KITTITAS COUNTY COMMUNITY DEVELOPMENT SERVICES

April 21, 2023

RE: CU-23-00002 The Outpost – Deemed Incomplete and Request for Additional Information

**CONCEPTUAL SITE PLAN
MULTIPLE PARCELS**

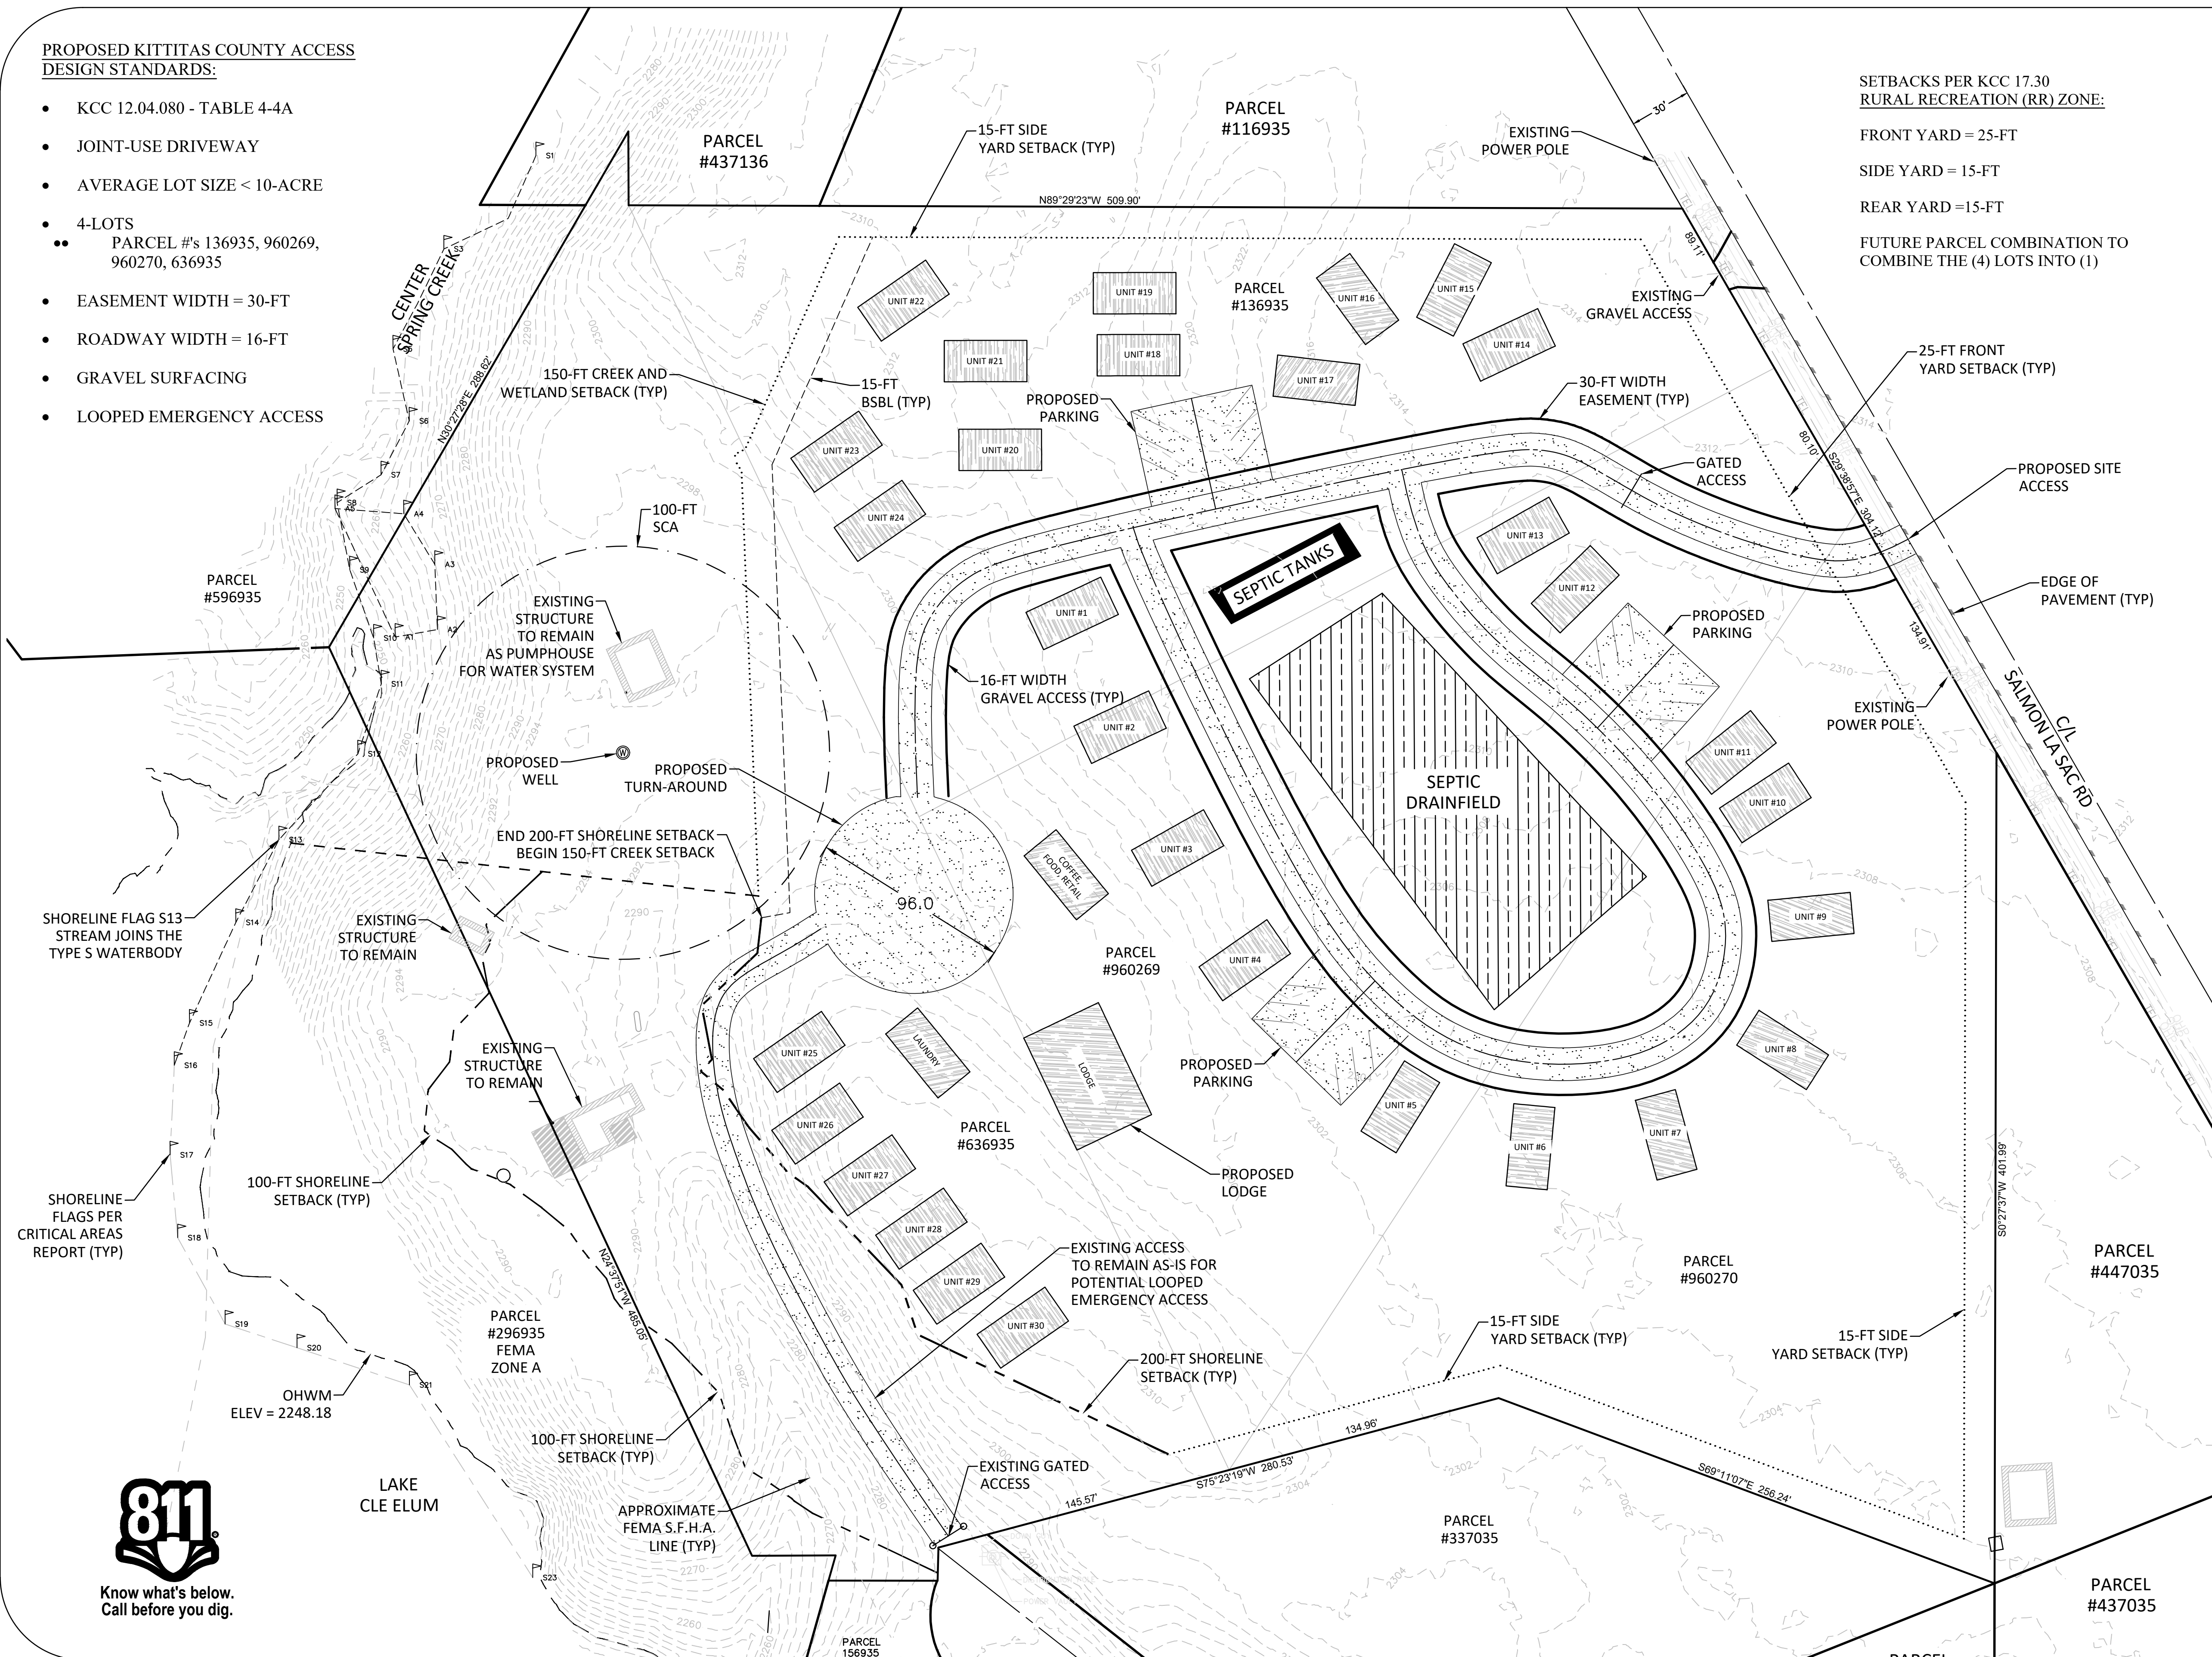
- 1) Please provide a scaled site plan (the provided site plan does not appear to have been printed to scale) that indicates any existing or proposed buildings and/or structures that are to be used with the campground/guest ranch.

- a) Additionally, in relation to KCC 17A – Critical Areas, appropriate setback buffers to any critical areas which are on or adjacent to the subject property shall be shown on the scaled site plan. The Type F stream located on and adjacent to parcel #636935 holds a 150-foot stream buffer with an additional 15-foot building setback. The submitted site plan appears to show development occurring within the stream buffer.
